**Application Reference:** 2026/0300

**Site Address:** 27 Quarry Street, Cudworth, Barnsley S75 8LS

**Introduction:** This application seeks full planning permission for a 2 storey side and rear extensions to dwelling

P.7

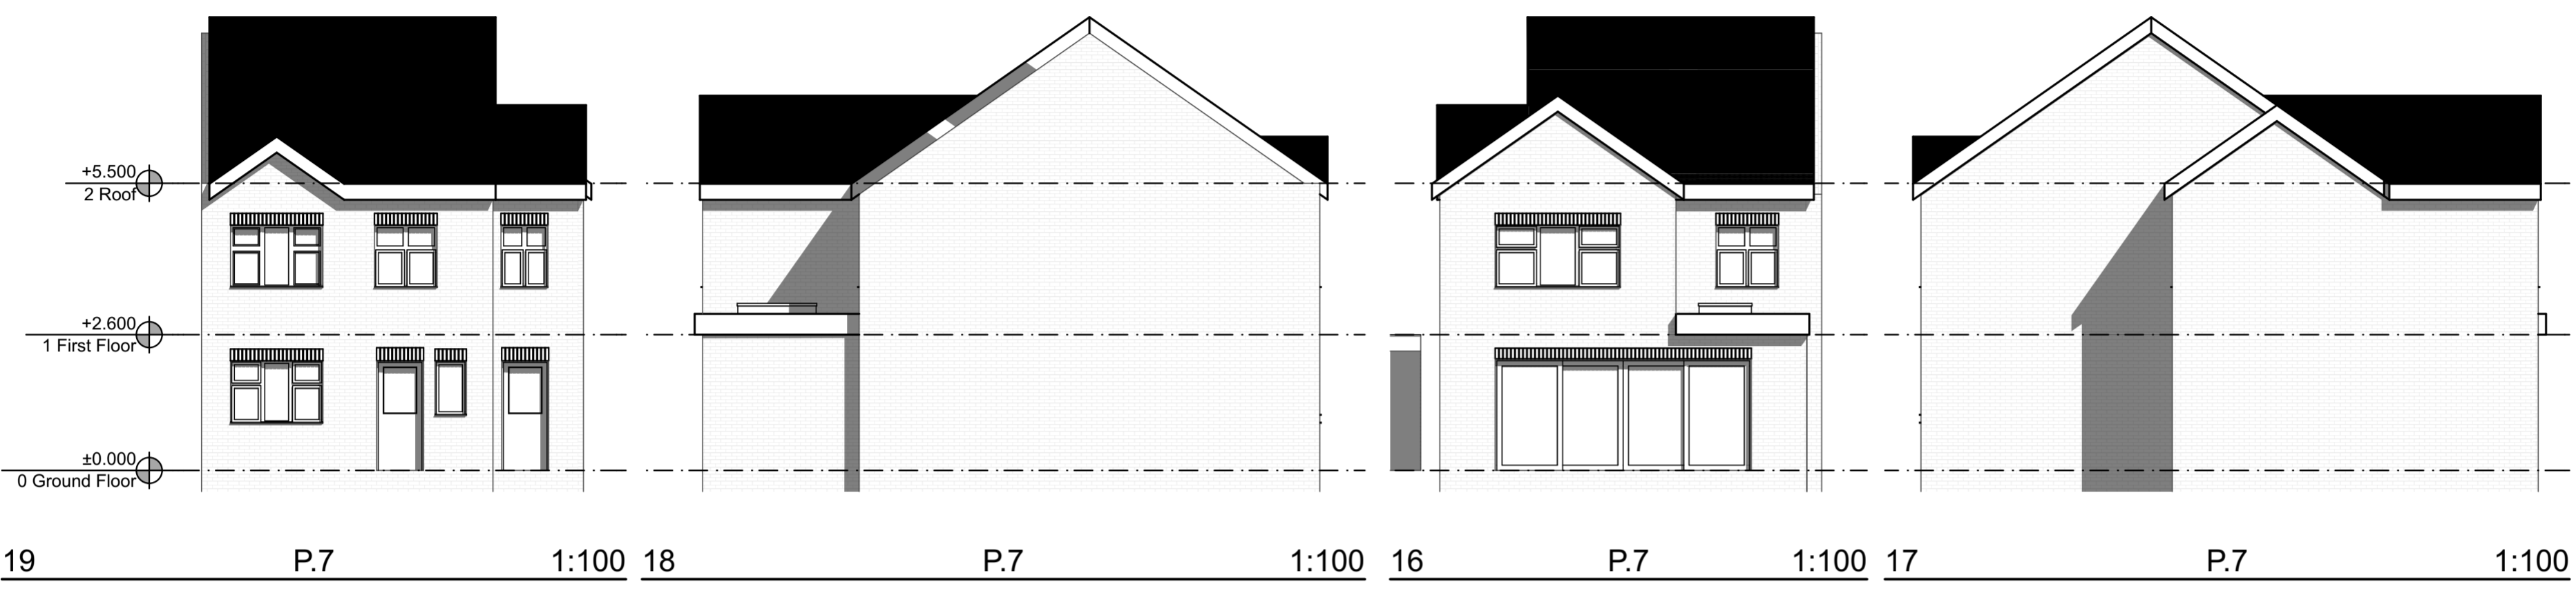
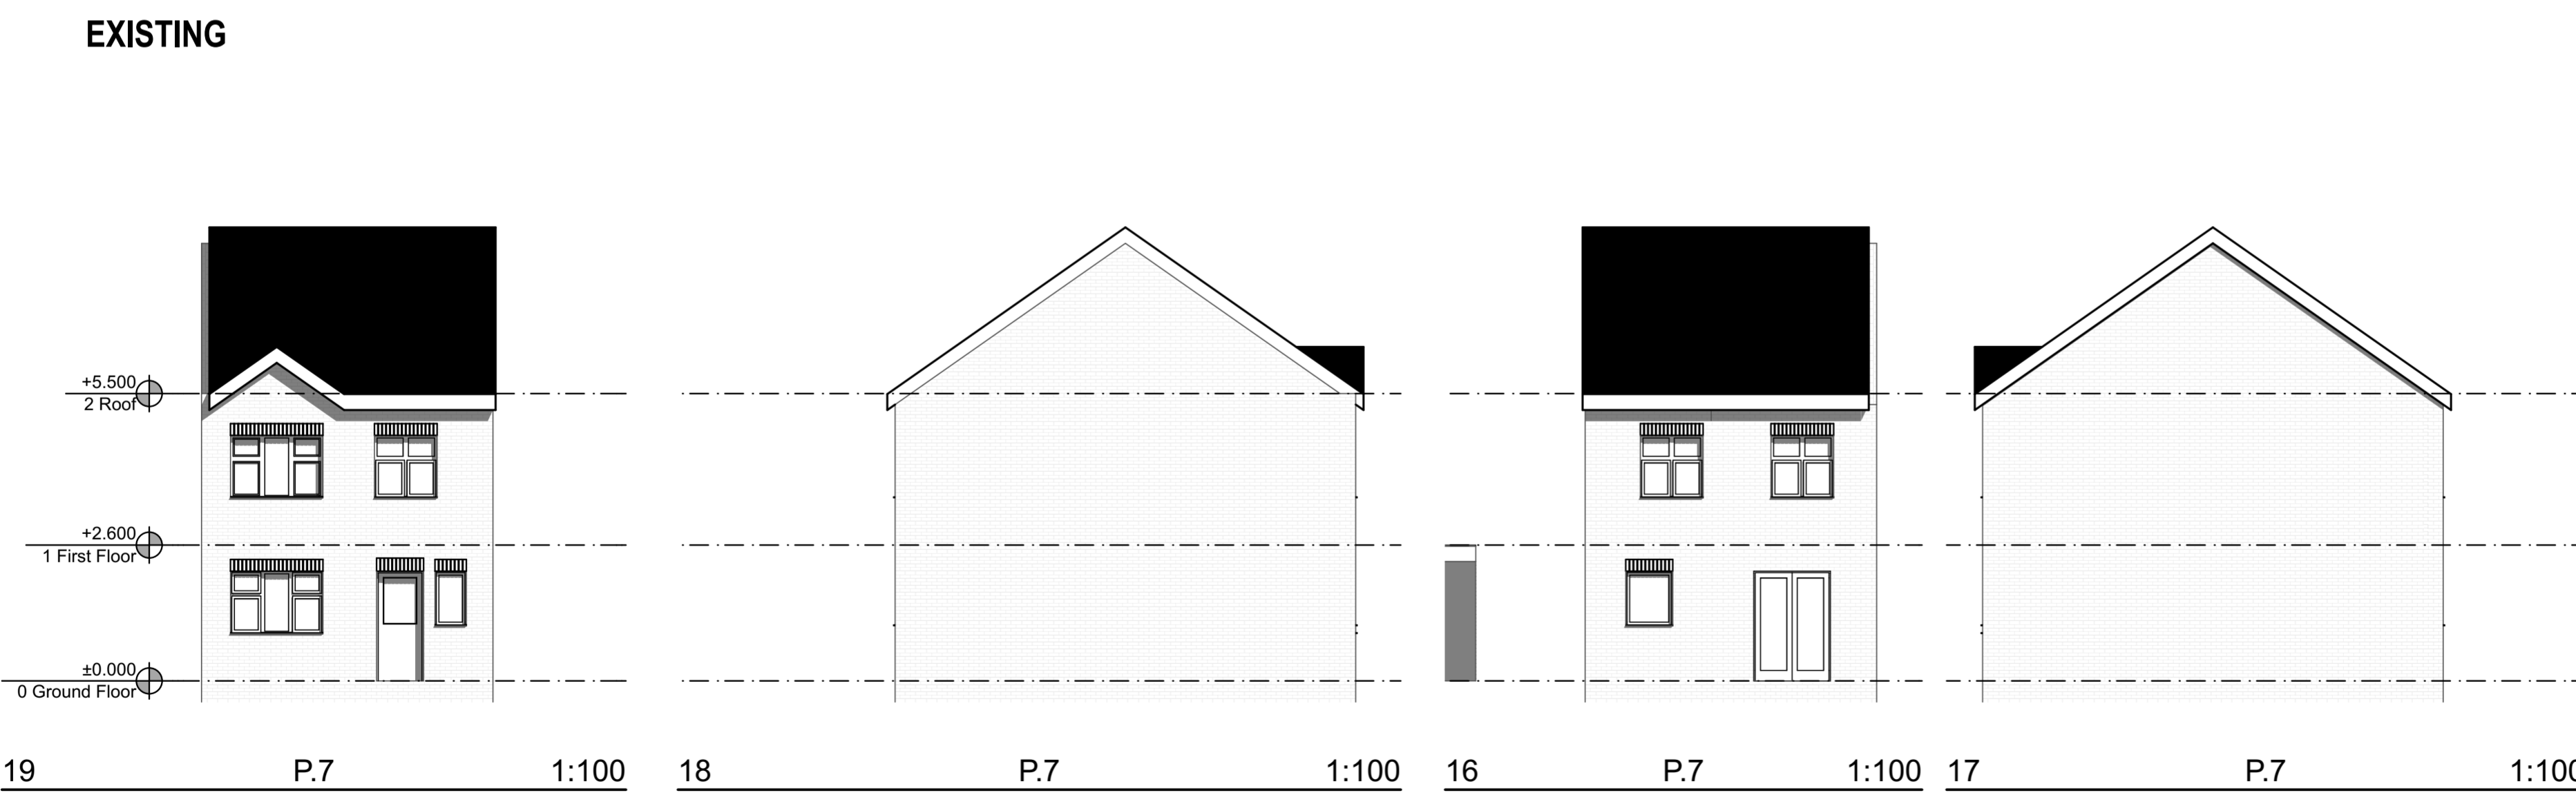
In approximate measurements, the side aspect of the extension is set back from the front elevation of the house by 4.8m, and extends rearwards for 7m, including 3m beyond the rear elevation of the dwelling. The side projection extends 1.73m, which practically fills the existing space between the dwelling and its side boundary although the width is far less than the allowable two-thirds of the existing dwelling's 5.88m width.

Approximate measurements for the rear aspect of the extension are a 3m projection from the rear elevation of the house, and a 7.02m width incorporating the 1.73m width of the side extension. The first-floor aspect of the two-story extension is set in by 2.5m from the side boundary with the attached neighbouring dwelling, giving a first-floor width of 4.52m, again incorporating the 1.73m of the side extension. Within the 2.5m setback from the side boundary, the roof of the ground floor extension overhangs by 0.15m (15cm), and there is a central rooflight, with height of about 20cm above that of the flat roof.

Additional space is proposed to be created within the roof space but there is no proposed increase to the roof height of the original dwelling. The original height of the eaves and roof remain at approximately 5.9m, and 9.09m respectively. The proposed side and rear extension feature a matching eaves height of approximately 5.9m and a reduced roof height of 7.4m.

As noted with the scale, the proposed design of the extension, through use of matching materials, a good set back from the front elevation, and a good step down of the roof would all minimise the impact on the design and character of the dwelling and meet some of the criteria outlined in the SPD House Extensions and Other Domestic Extensions. One criterion from the SPD, which is not met, is the requirement for a 1m gap being maintained between a side extension and a boundary. However, on this occasion with the unusual and heightened position of the application dwelling, the impact of not maintaining a 1m gap would only have a modest impact on the scale, design and character of the dwelling, whilst other aspects of the proposal would have a limited impact.
